DECISION DELEGATED TO DEVELOPMENT MANAGER**DECISION DELEGATED TO DEVELOPMENT MANAGER**

Application No: H16-0619-20 **Applicant:** Mr D Burchnall

Proposal: Conversion of dwelling into 7 single person HMO

Location: Rosante 23 West Elloe Avenue Spalding

10 - Proposed Ground Floor Schedule		
Name	Area	Perimeter
Bed 1	10.75 m²	14.0 m
Bed 2	7.85 m²	12.8 m
Bed 3	10.95 m²	14.1 m
En Suite 1	2.85 m²	7.0 m
En Suite 2	1.95 m²	5.6 m
En Suite 3	3.05 m²	7.3 m
Grand total 6	37.45 m²	60.8 m

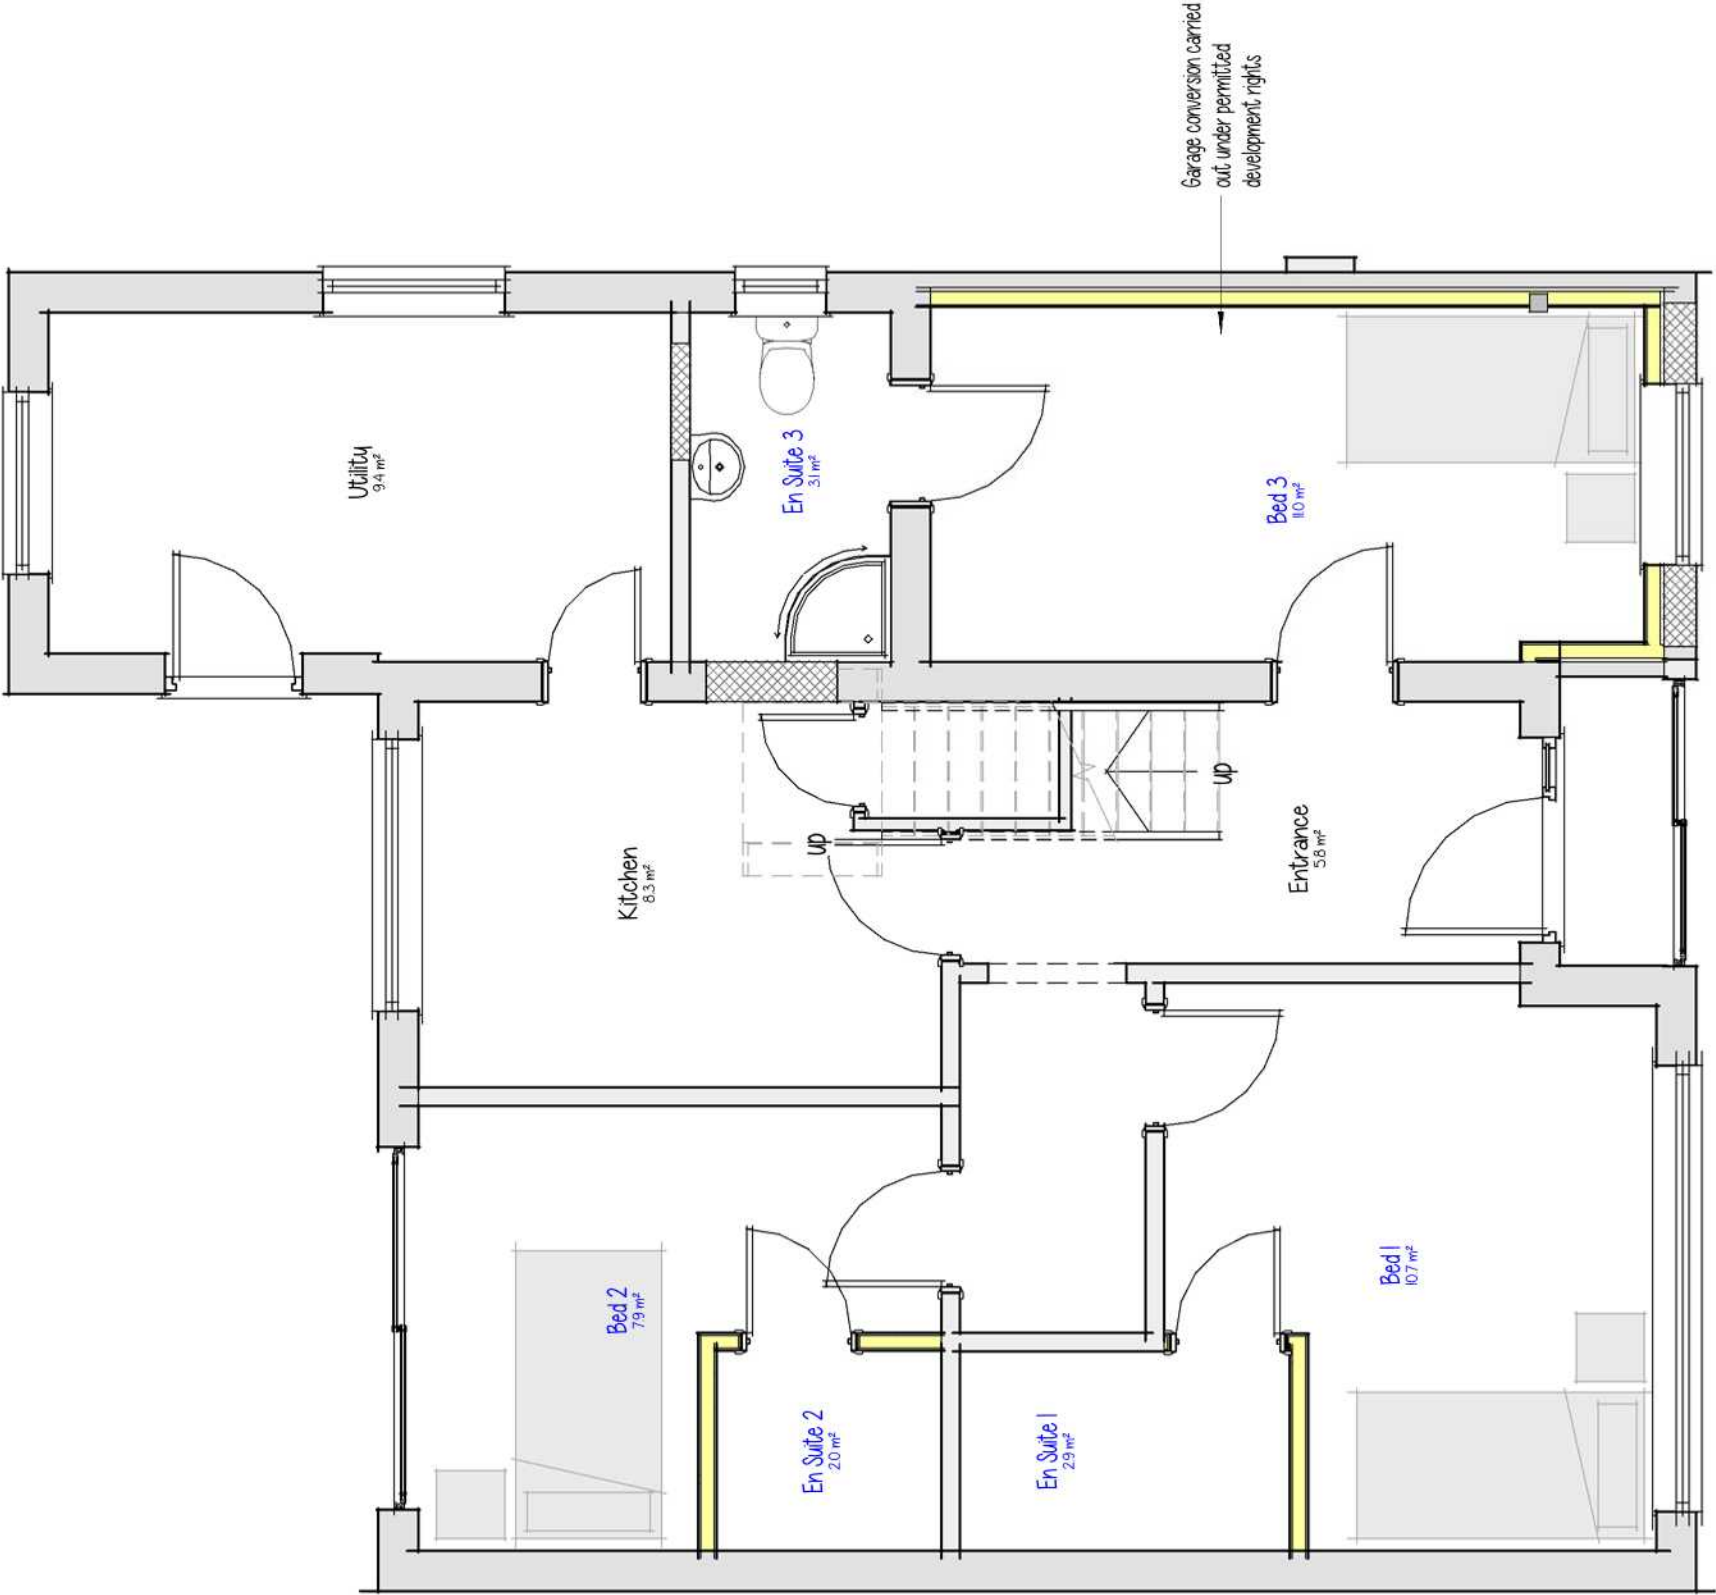
The proposal seeks to provide three bedrooms, three en-suites, a kitchen and a utility at ground floor level. At first floor level four bedrooms, four en-suites and a bathroom are to be sited. A garage would be converted at ground floor level to create one of the three downstairs bedrooms. No additional windows are to be installed at first floor level.

The SFRA indicates that the site is within an area identified as "Danger to Most". The proposal is introducing bedrooms onto the ground floor and is therefore considered to be a more vulnerable use with an increased risk to occupants. There are alternative sites within Spalding that are at a lower risk of flooding. Consequently, the proposal fails to satisfy the sequential test.

Whilst the Local Planning Authority does have concerns about storage space, especially in Room 2, the Private Sector Housing Officer has no objections to the proposal.
